SUBMISSION TO NSW DEPARTMENT OF PLANNING, HOUSING AND INFRASTRUCTURE

Re: SSD-96272465 – 11–23 Rangers Avenue, Mosman (the Development)

Figure 4 Existing traffic flows – Rangers Avenue / Park Avenue

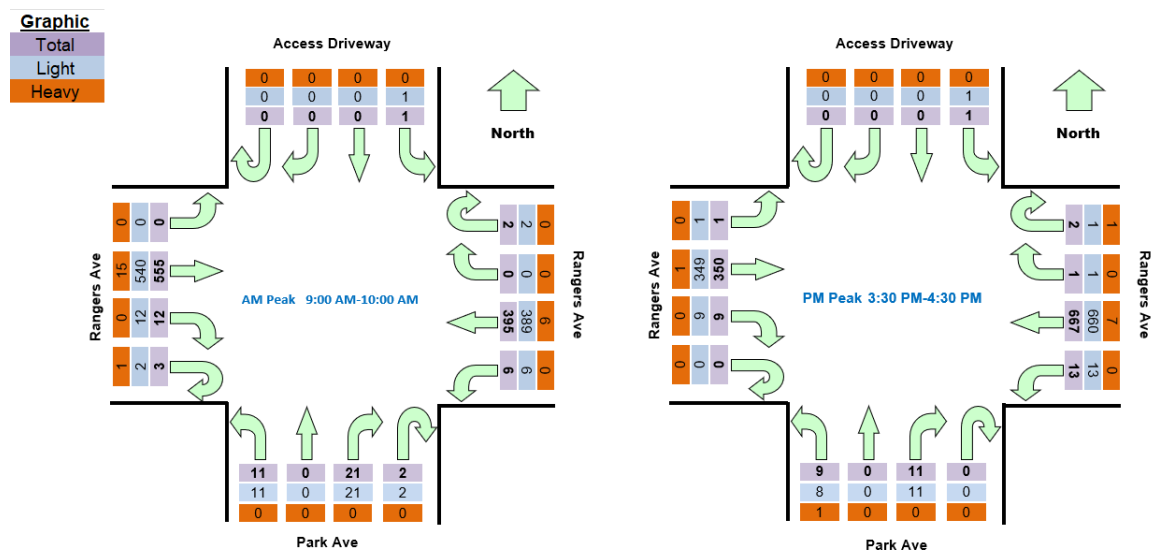
- a. Firstly, Figure 4 of the Report has been incorrectly drawn, thus giving a possible false impression as to efficacy of the Park Avenue Intersection. In reality, the proposed Access Driveway of the Development will not be adjacent to Park Avenue. In fact, such driveway will be located approximately 50 metres west of the current Rangers Avenue/Park Avenue intersection;
